M42 Junction 6 Development Consent Order Scheme Number TR010027

8.98 Applicant's Comments on any Additional Information or Submissions Received by Deadline 8

**Applicant's Comments on any Additional Information or Submissions
Received by Deadline 8**

Version	Date	Status of Version
1	15 November 2019	Final for submission at Deadline 9

Figure 7.2: DS 2021 and 2041 peak hour flows

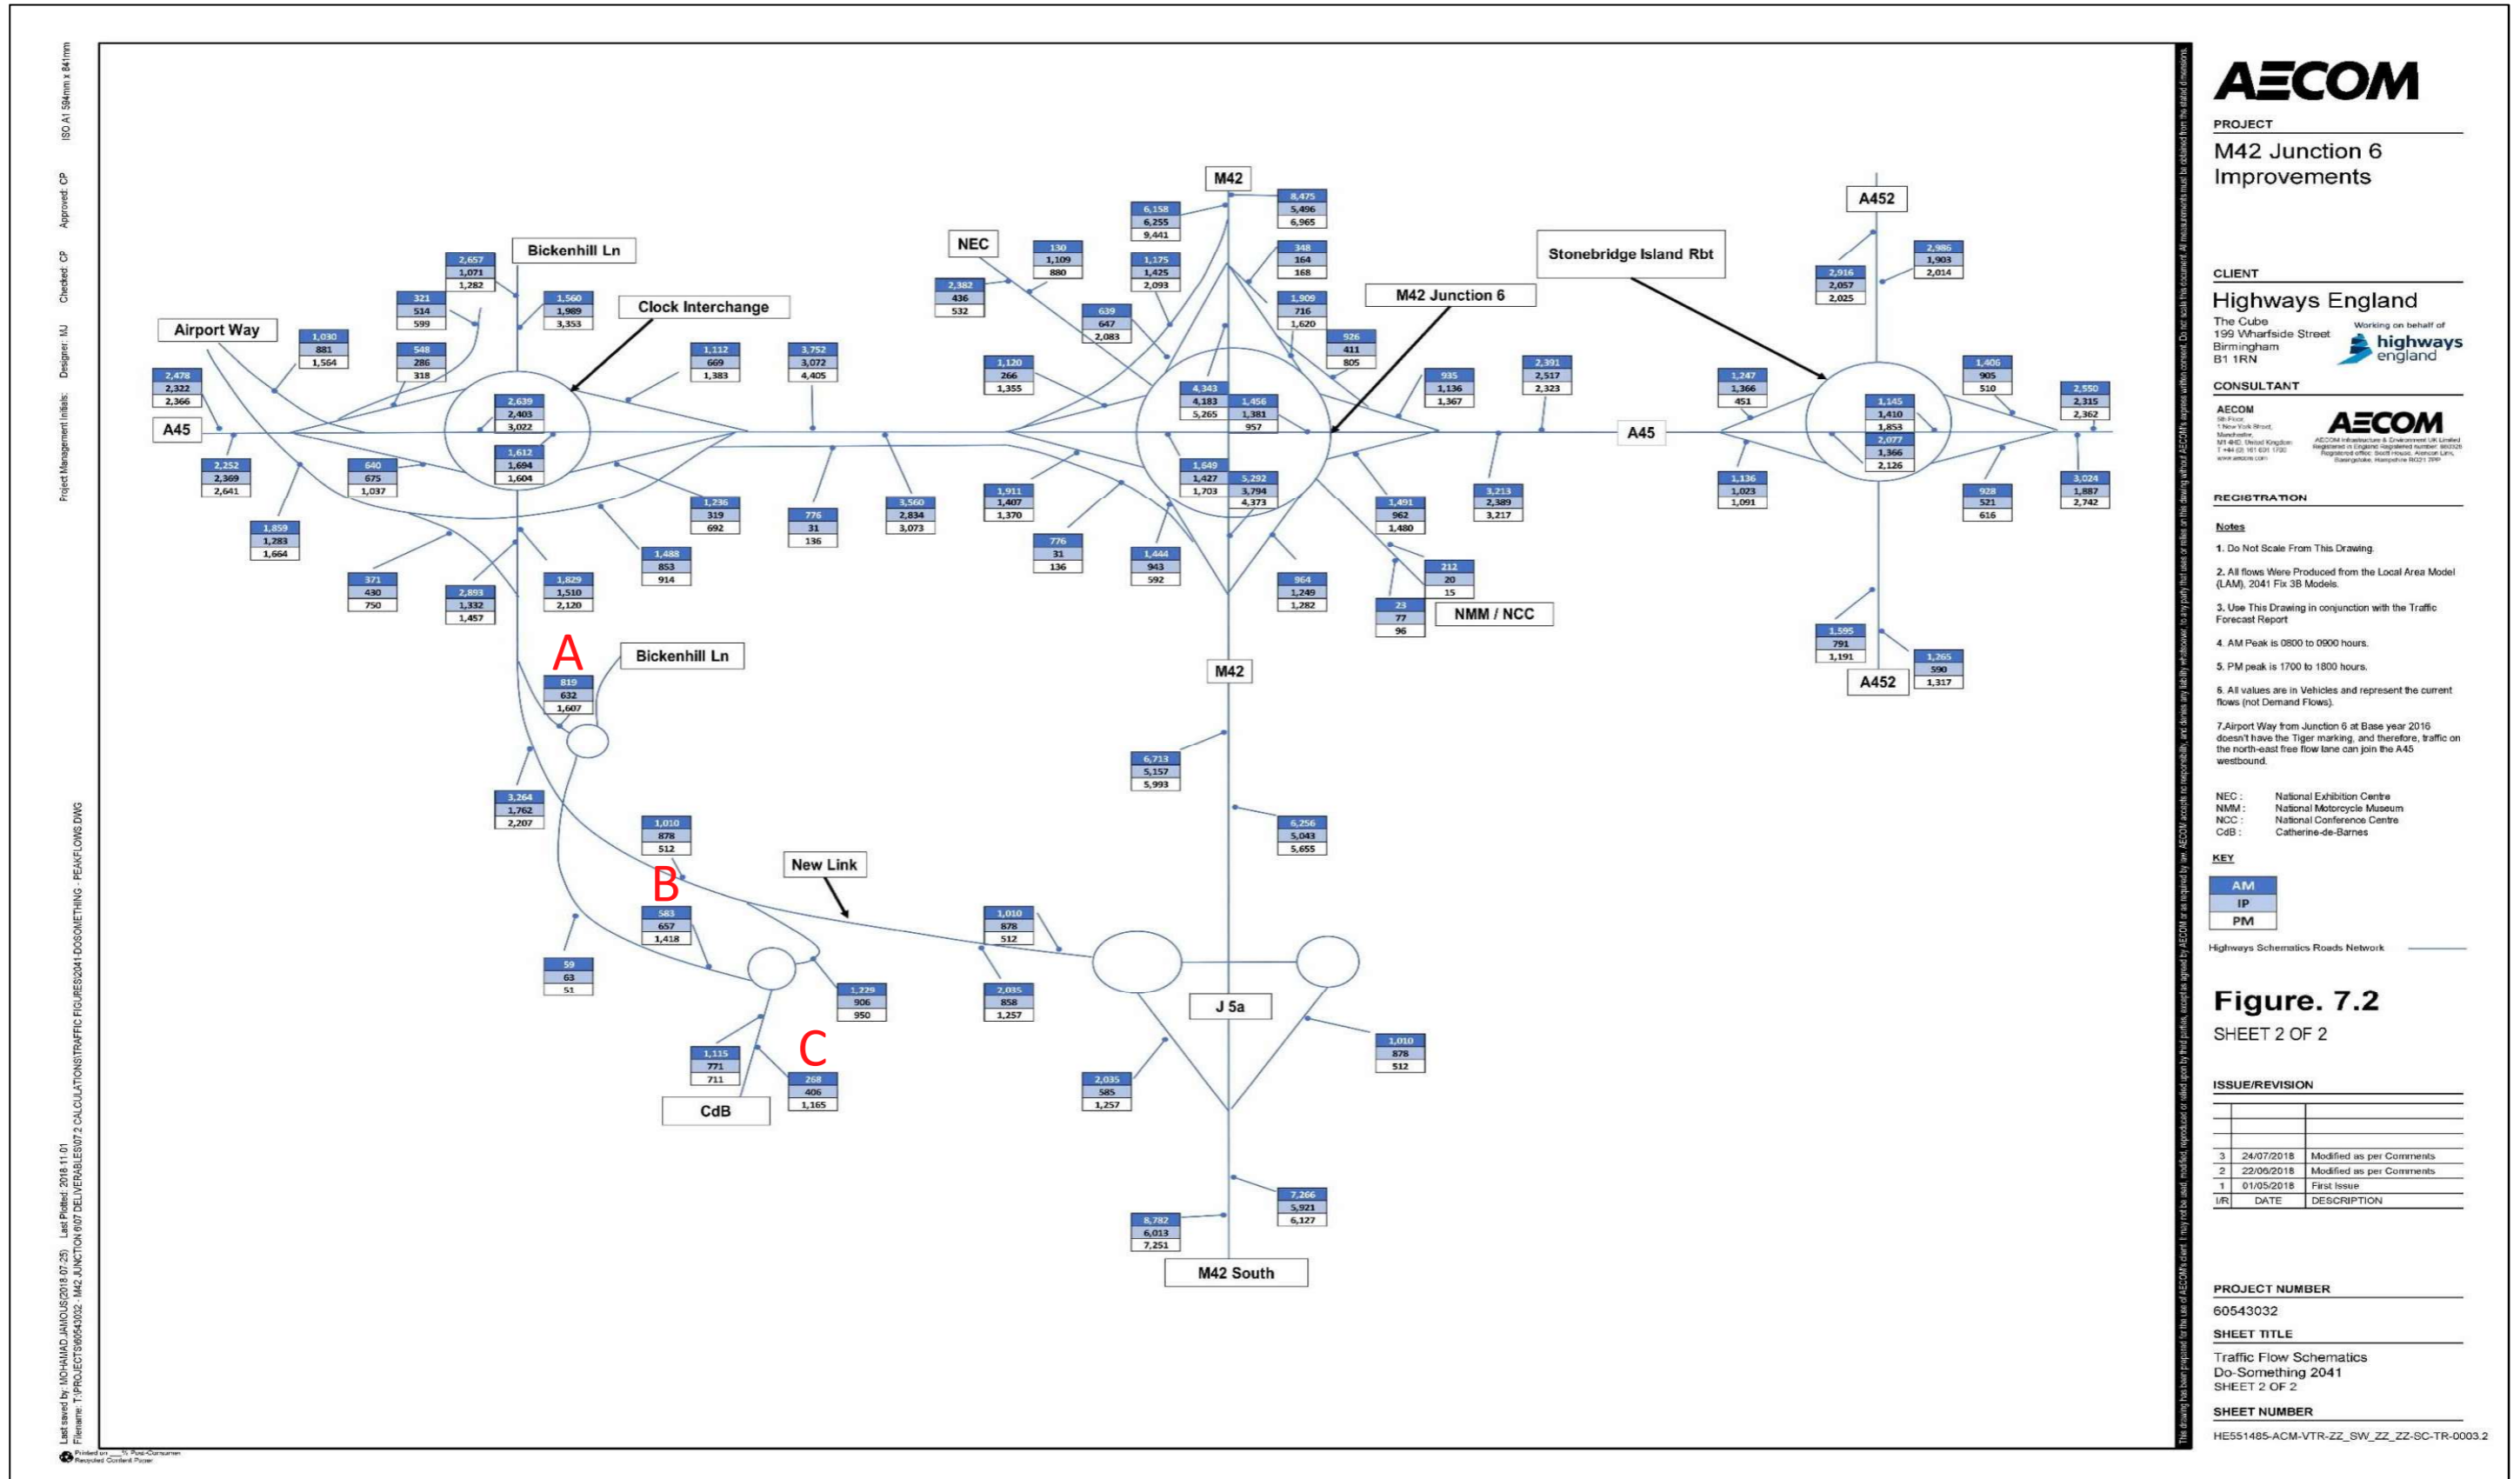
Submitted by	Title	Comments																																			
		<p>Figure 7.2 - Do-Something 2021 – 2041</p>

<ul style="list-style-type: none"> - Do-Something will result in a higher southbound Traffic Flow of 1607 during PM hours in 2041 compared to the Do-Minimum Traffic Flow of 1390 - There is an increase in southbound Traffic Flow in 2041 at the north end of Catherine de Barnes Lane but there is a reduction in Traffic Flow at the south end - There appears to be a false assumption that a lot of traffic is / will be using Shadowbrook Lane - Most of the vehicles that arrive at Bickenhill Roundabout from the Mainline Link road in AM hours in 2041 will apparently not reach Hampton Lane Roundabout - 819 vehicles arrive at Bickenhill Roundabout but only 268 vehicles will get to Hampton Lane Roundabout - More than a third of the vehicles that arrive at Bickenhill Roundabout from the Mainline Link road in IP hours in 2041 will apparently not reach Hampton Lane Roundabout - 632 vehicles arrive at Bickenhill Roundabout but only 406 vehicles will get to Hampton Lane Roundabout - More than a quarter of the vehicles that arrive at Bickenhill Roundabout from the Mainline Link road in PM hours in 2041 will apparently not reach Hampton Lane Roundabout - 1607 vehicles arrive at Bickenhill Roundabout but only 1165 vehicles will get to Hampton Lane Roundabout - Southbound Traffic Flow during inter-peak hours from Bickenhill Roundabout to Barber's Coppice Roundabout to Hampton Lane Roundabout is shown higher than during AM hours by 2041 		(A) Diverge Slip from proposed Mainline link to Bickenhill Roundabout		(B) Southbound Realigned Catherine de Barnes Lane from Bickenhill Roundabout to Barber's Coppice Roundabout		(C) Southbound Realigned Catherine de Barnes Lane from Barber's Coppice Roundabout to Hampton Lane Roundabout		Year	2021	2041	2021	2041	2021	2041	AM	643	819	563	583	359	268	IP	473	632	496	657	372	406	PM	1396	1607	1315	1418	1149	1165
	(A) Diverge Slip from proposed Mainline link to Bickenhill Roundabout		(B) Southbound Realigned Catherine de Barnes Lane from Bickenhill Roundabout to Barber's Coppice Roundabout		(C) Southbound Realigned Catherine de Barnes Lane from Barber's Coppice Roundabout to Hampton Lane Roundabout																																
Year	2021	2041	2021	2041	2021	2041																															
AM	643	819	563	583	359	268																															
IP	473	632	496	657	372	406																															
PM	1396	1607	1315	1418	1149	1165

Submitted by	Title	Comments
		<p>- In 2041, 12953 more vehicles will exit Clock Interchange traveling south and 11275 of these vehicles will continue onto the Mainline Link road. It appears there will be an increase of 1678 vehicles using the Realigned Catherine de Barnes Lane in 2041</p> <p>Given the above it is difficult to conclude that Highways England are correct when stating the annual average daily Traffic Flow southbound to Catherine-de-Barnes Lane shall be 8,532 under the do minimum scenario compared to 8,348 under the do something scenario.</p> <p>In fact, it is glaringly obvious that they have simply cherry-picked data in an attempt to justify their argument.</p> <p>It also appears that their Traffic Flow data is seriously flawed.</p> <p>As HE have used this flawed Traffic Flow data in their air quality assessment document 'TR010027-000139-TR010027_M42J6_6-1_Environmental_Statement_Chapter_6' and noise assessment document 'TR010027-000145-TR010027_M42J6_6-1_Environmental_Statement_Chapter_12' one must assume that these documents are not a true reflection of the impact of the scheme and they must be updated accordingly before any decision is made by the ExA.</p> <p>The Applicant comment:</p> <p>The Applicant's response to Action point 20 within Volume 8.86 [REP7-011/Volume 8.86] referred to southbound traffic along Catherine-de-Barnes Lane where it reaches Catherine-de-Barnes roundabout, not where it will reach the new Barber's Coppice roundabout. This is because the Applicant is of the view that this is the area currently most susceptible to the congestion described by Mr O'Reilly.</p> <p>Mr O'Reilly's subsequent comments largely relate to the traffic flow numbers not 'adding up' between road sections within the Transport Assessment Report (TAR) [APP-174/Volume 7.2]. The comments also question the validity of the traffic flow data which has been used to inform the air quality and noise assessments.</p> <p>The Applicant can confirm that the traffic flows presented in Figures 7.1 to 7.6 of the TAR provide a summary of the forecast flows produced by the M42 Junction 6 Local Area Model (LAM). As the figures referred to by Mr O'Reilly are summary figures, these do not provide flow information for</p>

Submitted by	Title		Comments
			<p>every road section which is why the totals do not add up and are not meant to. The Applicant's selection of links was made to simplify the presentation of the flows while allowing some comparisons to be made between forecast years and scenarios. The full information is contained in the LAM and informed both the traffic and environmental assessment, including the assessments of air quality and noise.</p>
Philip O'Reilly	Response to action points: ISH 7 on the draft Development Consent Order – 23 rd October 2019	16	<p>Philip O'Reilly comment:</p> <p>I can confirm a letter from Chris Harris (Highways England) was attached to an email received from Lydia Barnstable (AECOM) on 25th October 2019 and marked 'Private and Confidential'. However, it does not address the concerns I have raised. In short:</p> <ul style="list-style-type: none"> - The letter advises that I should engage a professional advisor but does not confirm that Highways England will meet the cost. - The letter confirms that works will be undertaken but does not provide any information or plan showing the extent of those works. - It is disappointing to say the least that Highways England are still unable to confirm how my property is affected by their scheme. - The letter does not confirm how the main access and the rear access to my property will be treated. - Instead of agreeing any fencing or boundary treatment to my property directly with Highways England it will need to be agreed with the Principal Contractor. - Although the works in front of my property have not changed a great deal since January 2018 Highways England have still not completed the Land Registry checks (but advise that they will be completed by 2nd November 2019) and therefore cannot confirm what land will revert to my ownership under the ad medium filum rule. No information has been provided prior to Deadline 8. - I would prefer to have control, and therefore ownership, of as much of the land outside the current boundary to my property up to the realigned Catherine de Barnes Lane to ensure it is properly maintained.
